**Re: Rio Vista Church, 8701 Golf Course Rd NW, Grading and Drainage Plan  
Engineer's Stamp dated 4-26-04 (C12/D2E)**

Re: Rio Vista Church, 8701 Golf Cours Rd NW, Grading and Drainage Plan  
Engineer's Stap dated 3-12-04 (C12/D2E)

**Re: Rio Vista Church, 8701 Golf Course Rd NW, Site Development Plan  
Engineer's Stamp dated 3-09-04 (C12/D2E)**

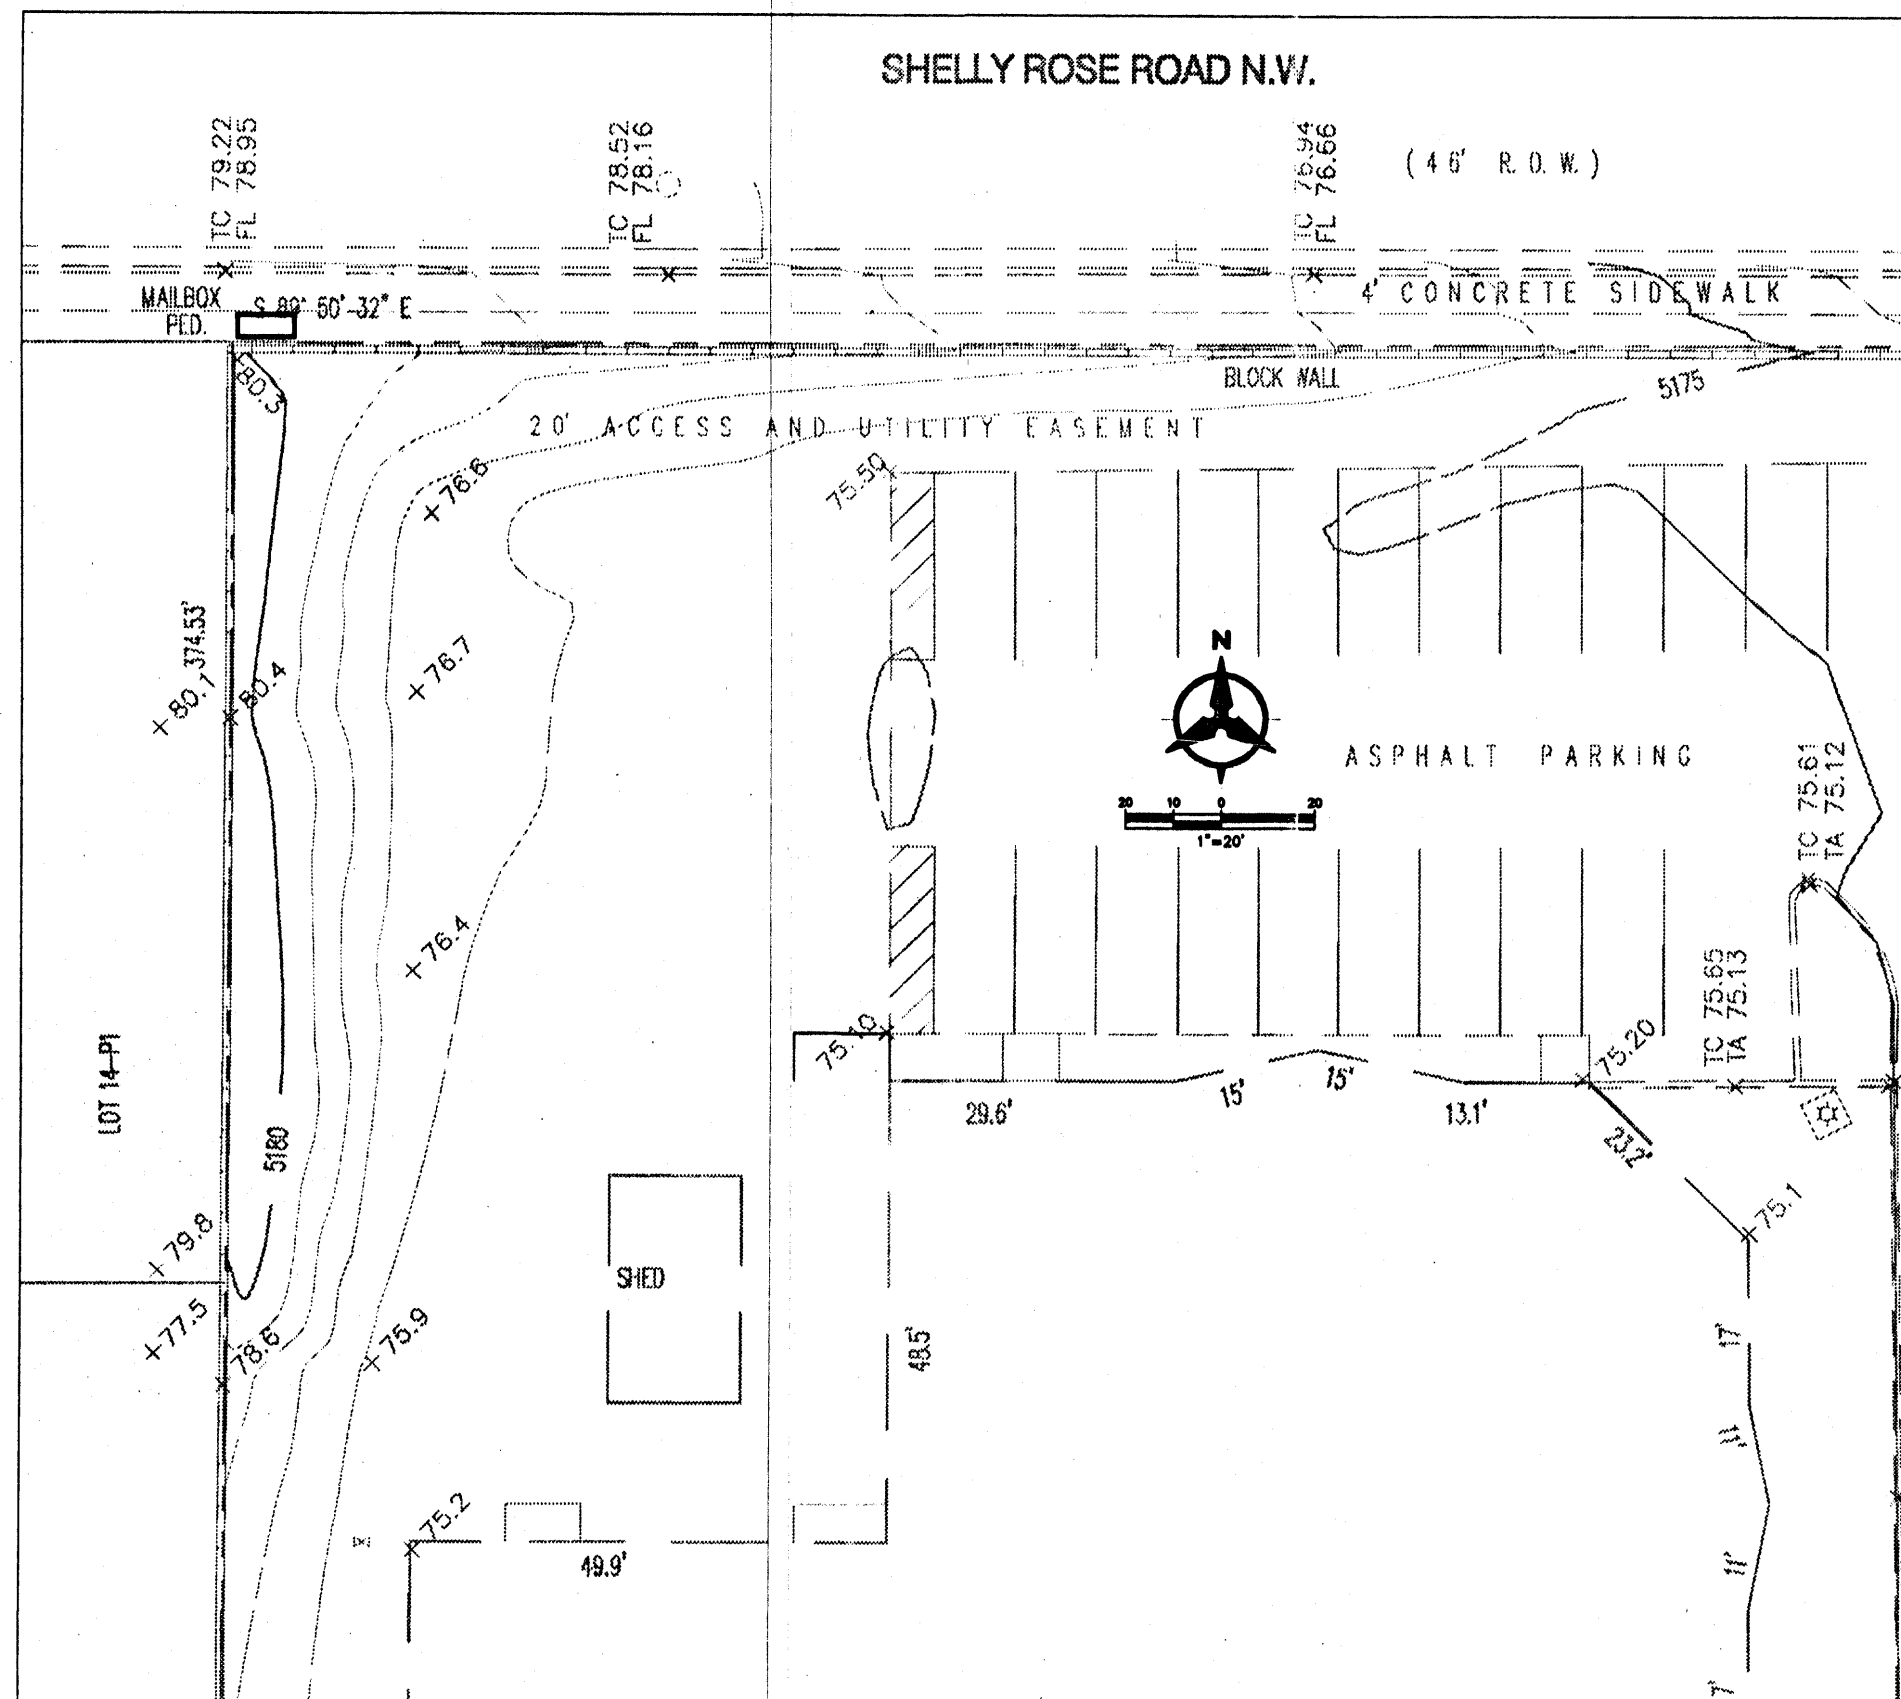
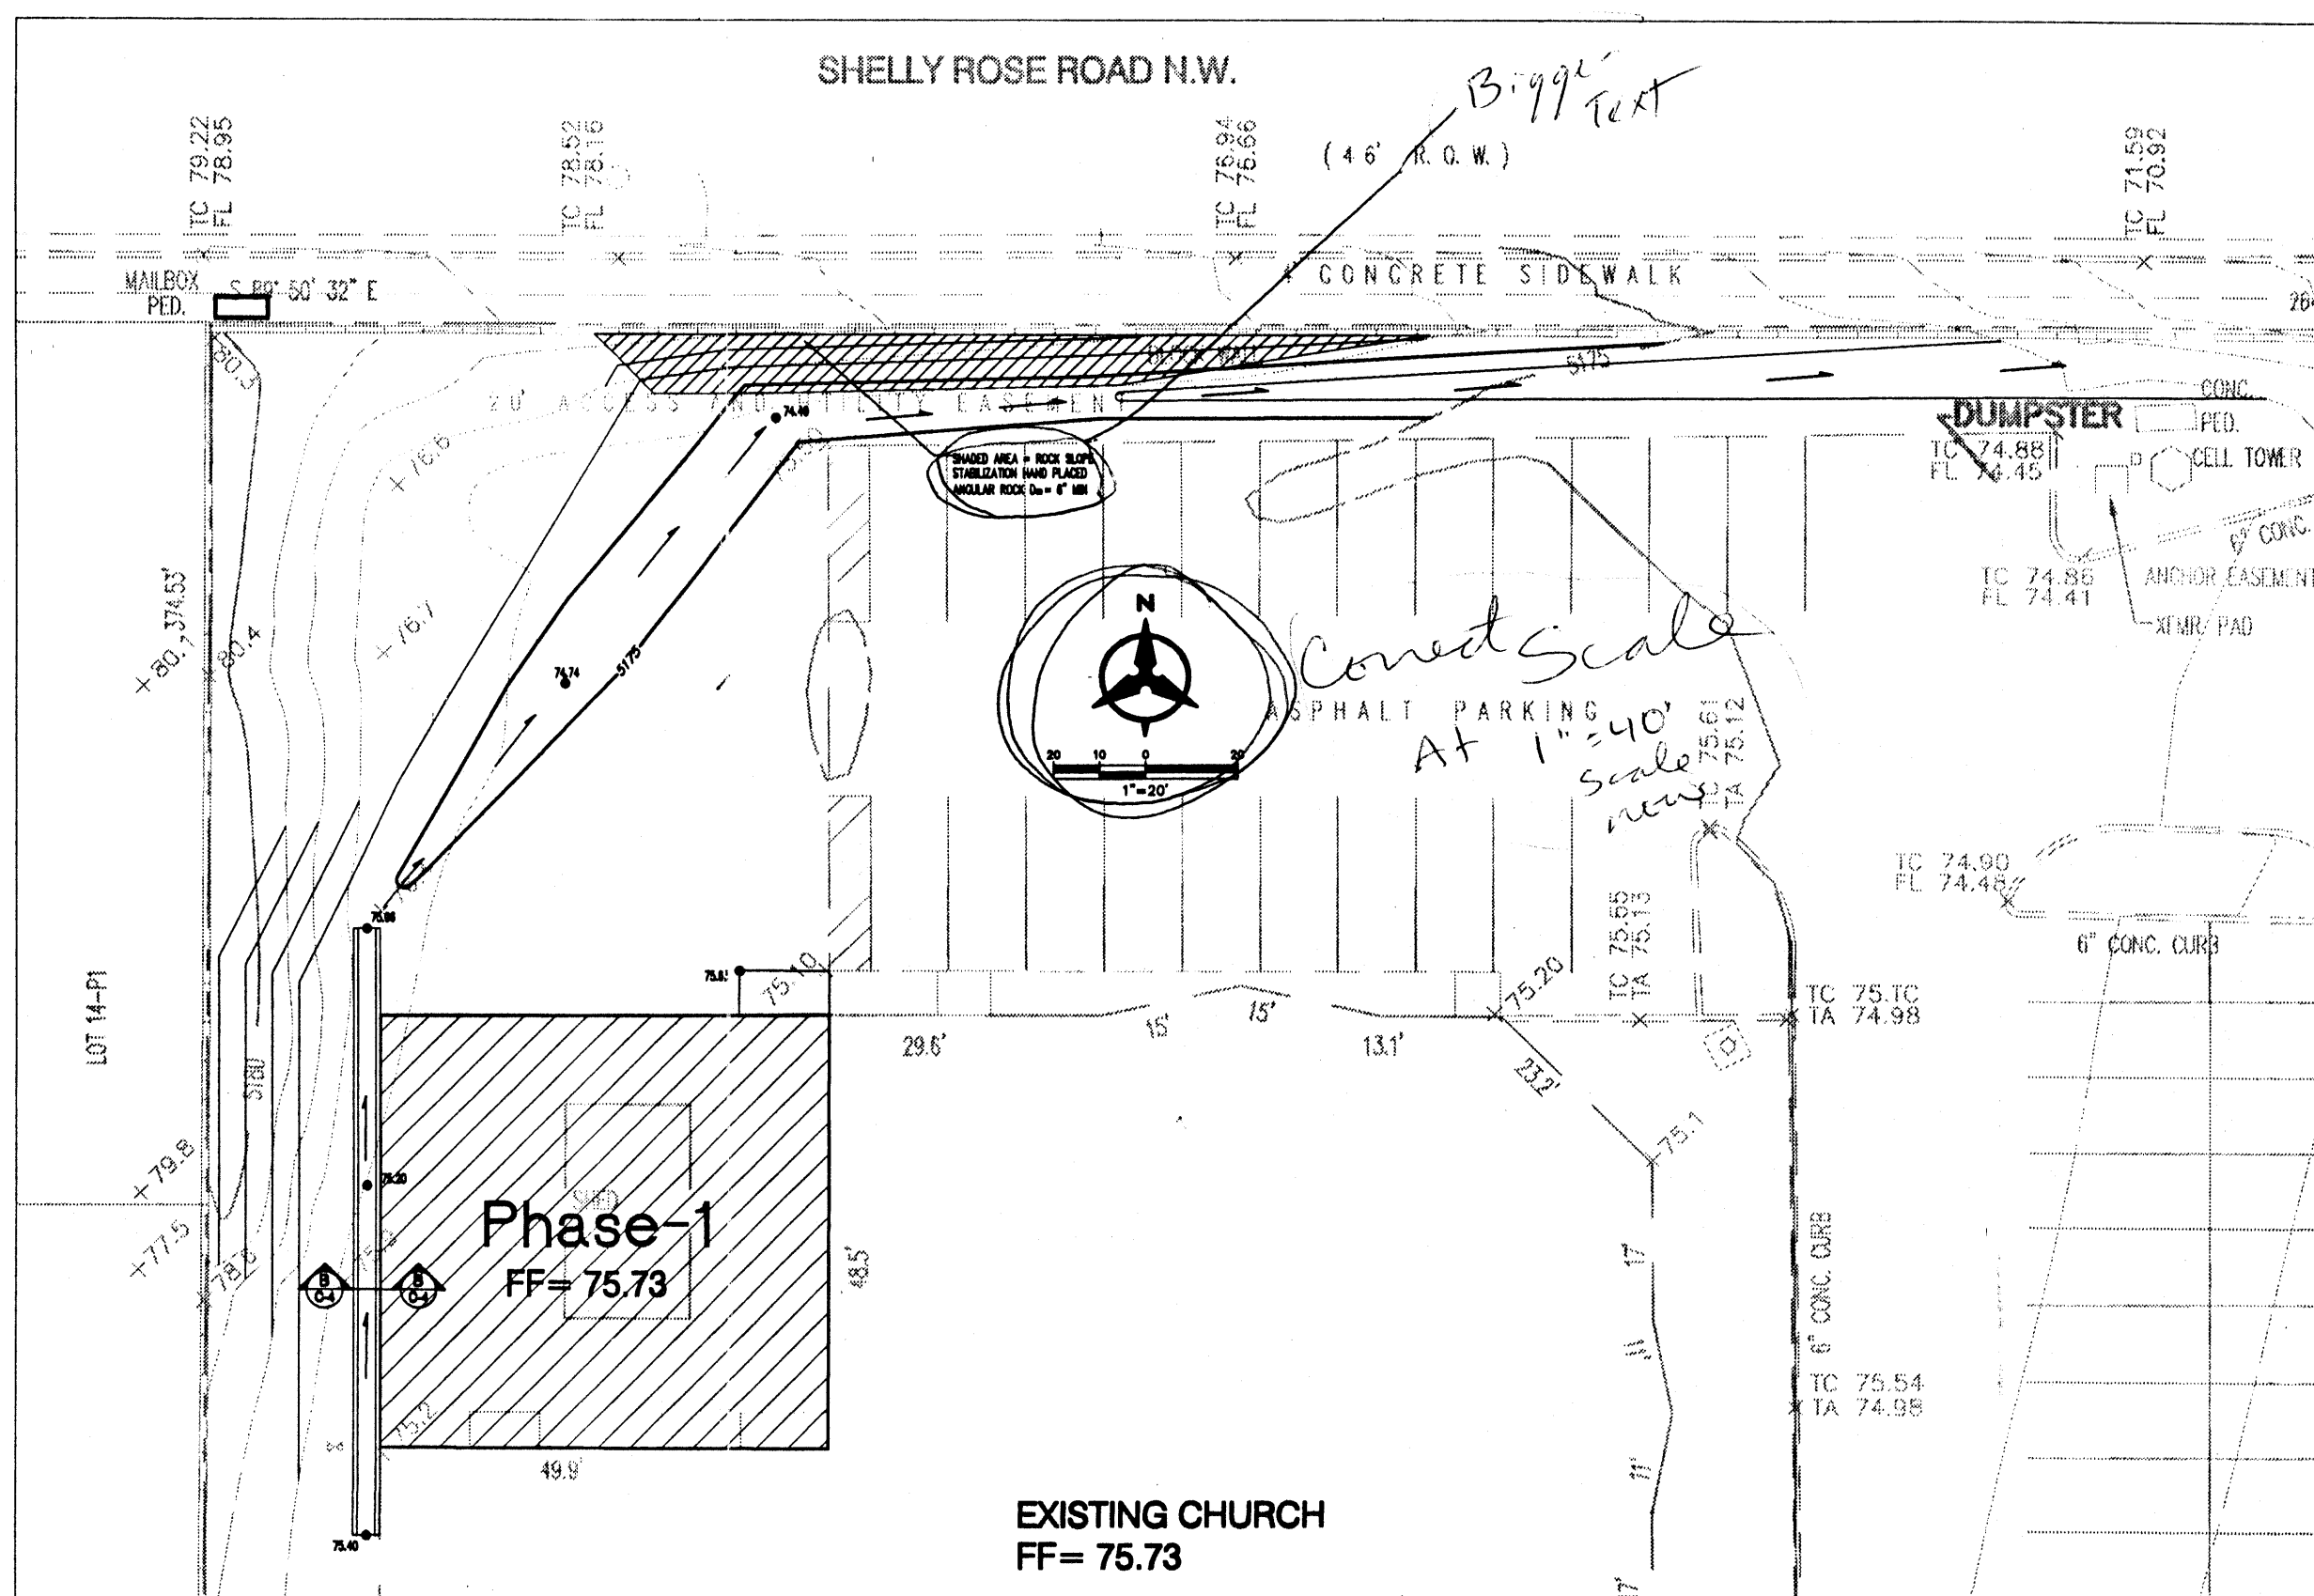
1. Provide an executive summary.
2. Please address offsite flow, if any exists.
3. Is this site located in a flood plain?
4. Provide a more detailed view of the proposed drainage structures, keeping in mind that a maximum of 12" storm drain is allowed per City Standards.
5. Show the drainage calculations and runoff quantities.
6. Please provide a benchmark.

- An executive summary is provided;
- There are no offsite flows impacting this site. This is shown in the executive summary;
- A drainage table is provided showing the existing and proposed drainage calculations;
- The Federal Emergency Management Agency Map is referenced in the executive summary stating the there is not a flood plain/zone within proximity to the site.
- There <sup>are</sup> ~~is~~ no proposed drainage structures planned for the construction of this phase so no structures will be shown.
- A benchmark is shown under the vicinity map on the upper right hand corner of the sheet.
